Erection of 1No. detached dwelling. This application affects the character and appearance of Craigweil House Aldwick Conservation area
Land to the side of Brus Lodge 28 Kingsway Aldwick

Thank you for your internet representation made on 9th July 2017 which has been recorded as '**an objection**' with the comments as follows:

Reference Planning application AW/155/17/PL

Tree Retention and Protection Plan

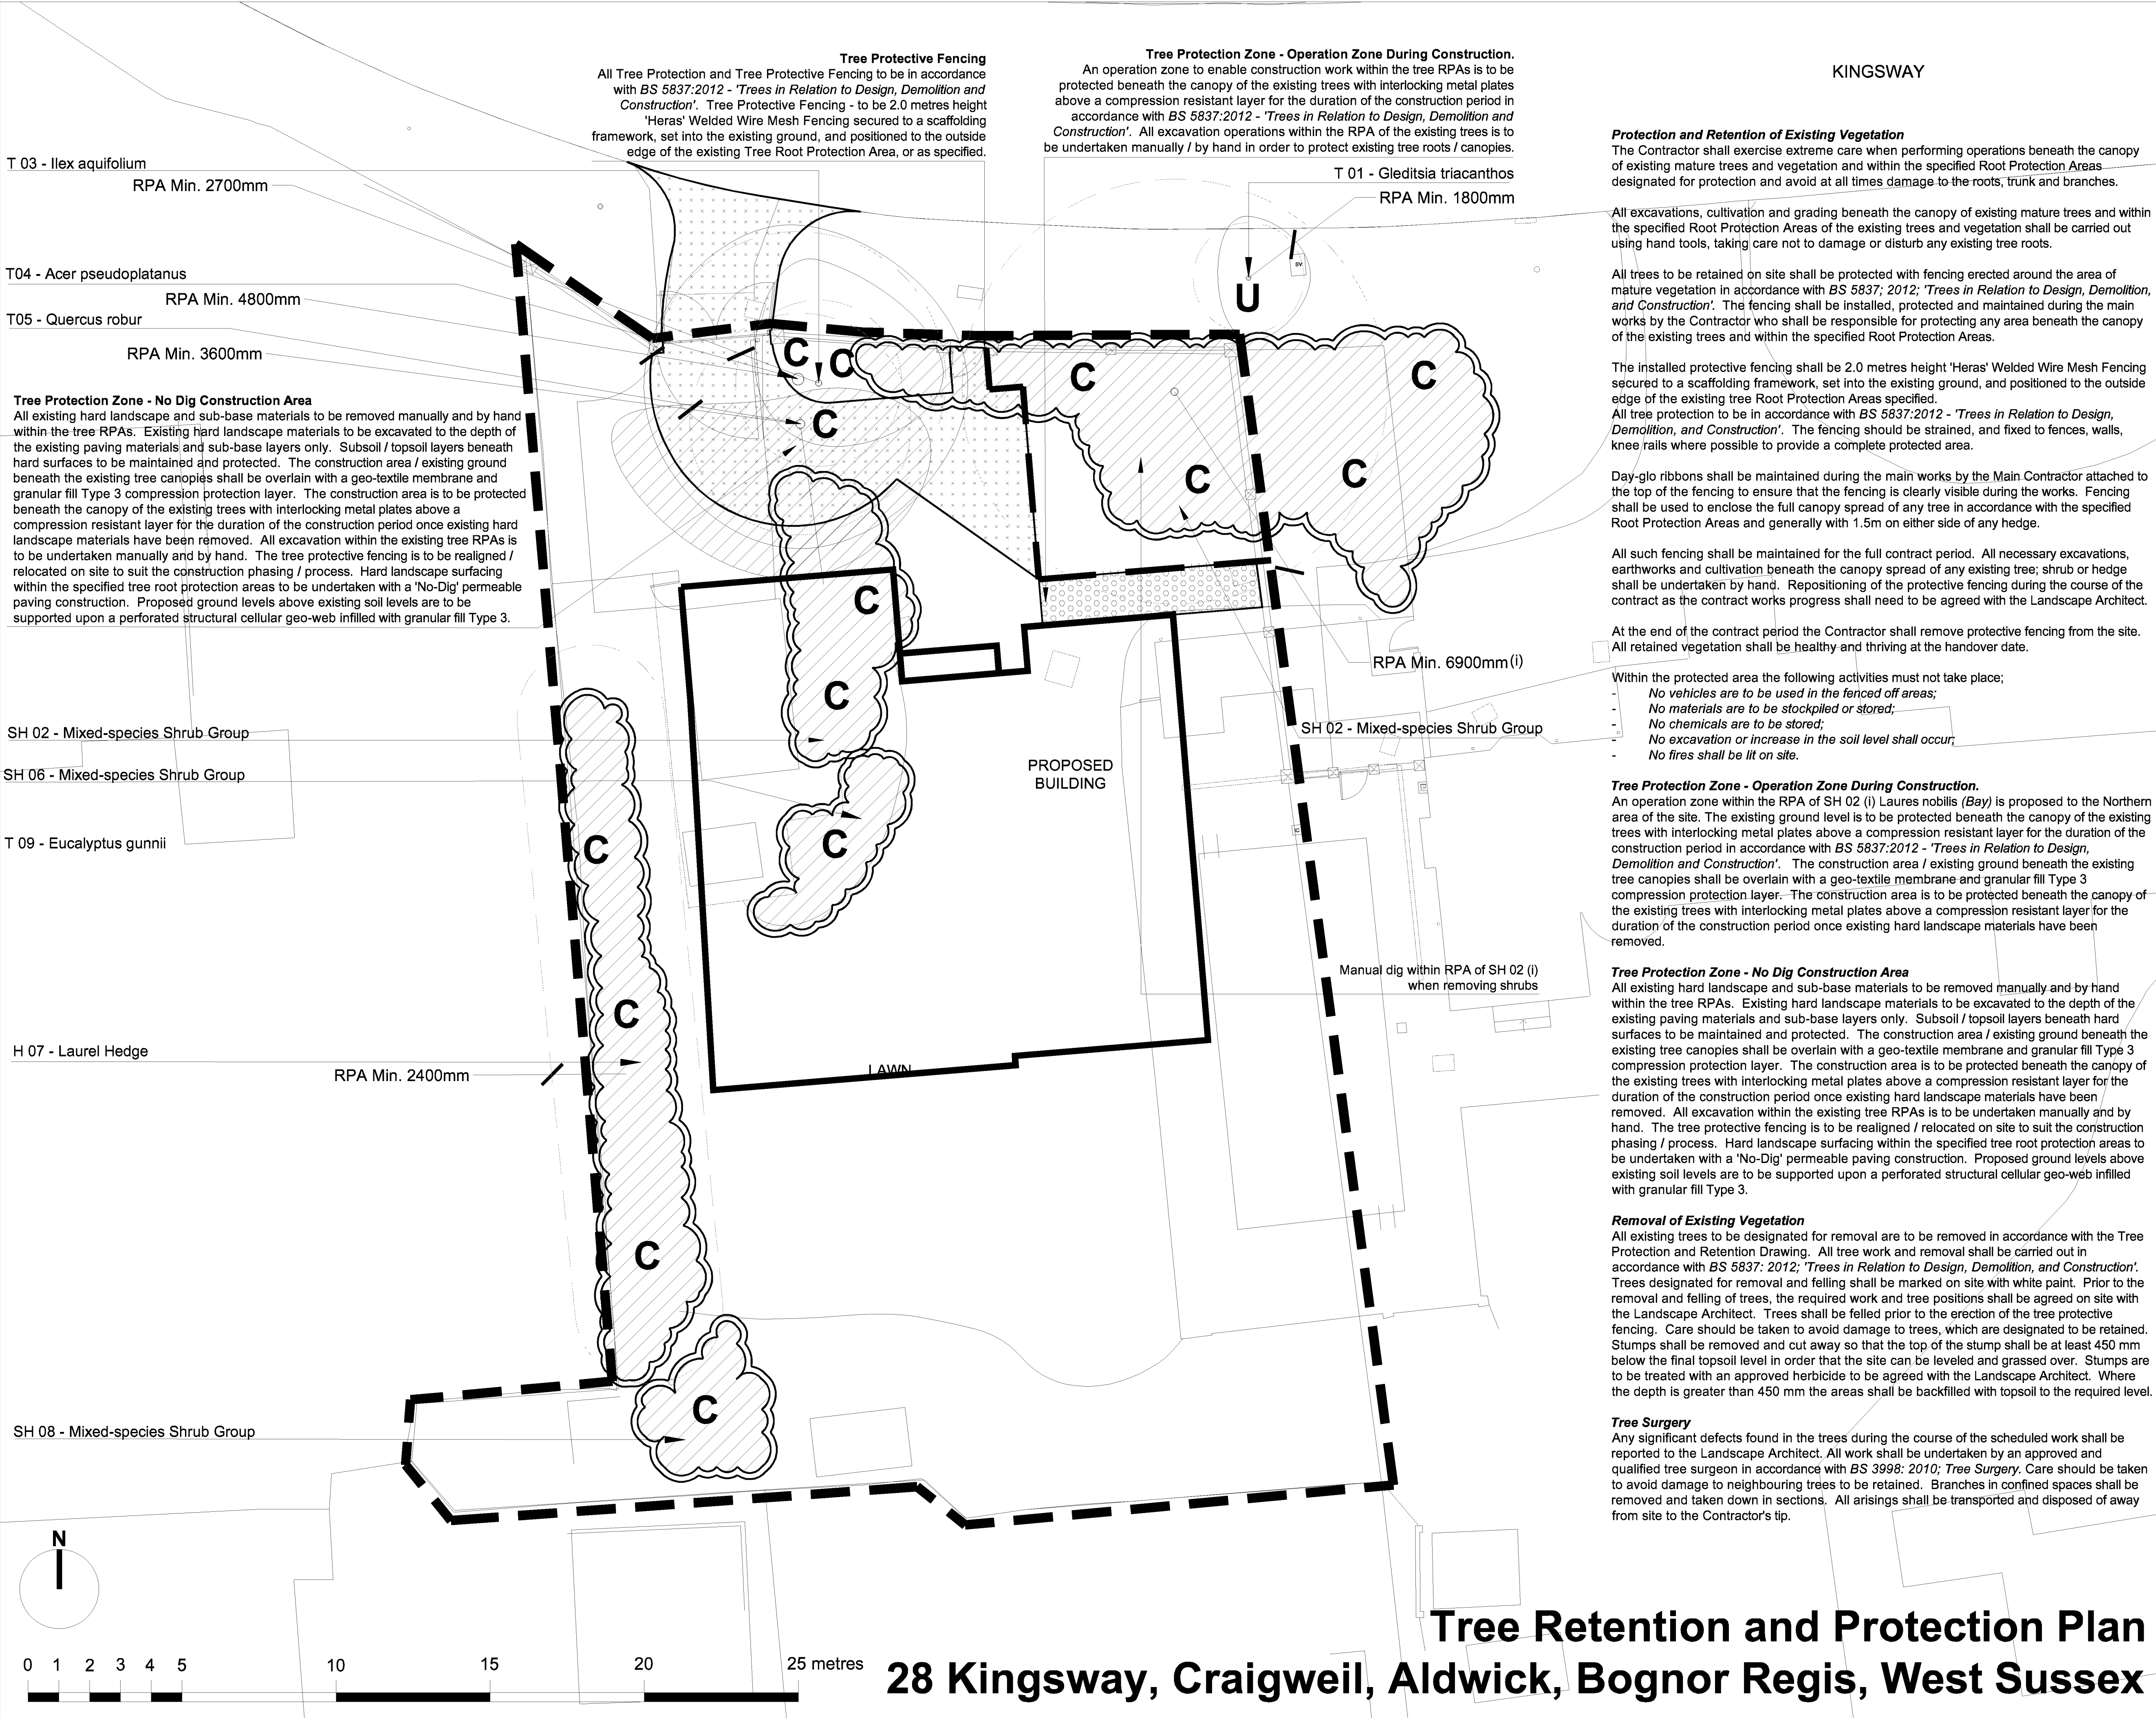
- 3. Looking at the drawings it shows the trees to the north side of the proposed property almost touching the house, how are they going to deal with further growth of these trees? In my opinion some major tree surgery is going to be needed to make a practical entrance to the property and to keep the trees off the new house.*

- 4. I object to the loss of trees/hedging and shrubs from the front of the proposed property and the loss of the general wooded area thus affecting the ambiance of the area and certainly would not enhance the Conservation Area.*

Dwg No  
PL25

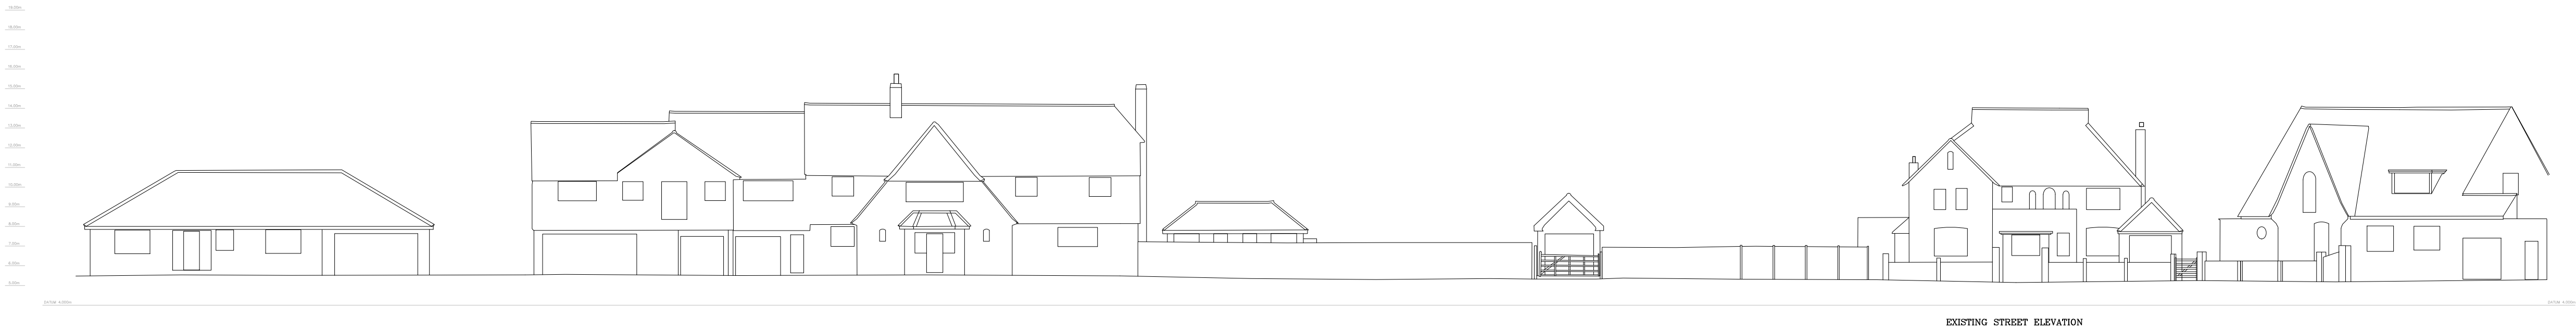
- 1. From the inspection of the plans I note that the proposed property although only shows a two story building I question why what appears to be six windows set in the roof are for and as in a previous planning application there was a proposal for a three story building. Are we going to get a further request after building work has started to add a further floor?*

- 2. The proposed property appears from the drawings to be forward of the general building line of other properties in this section of the road and also extends further back.*
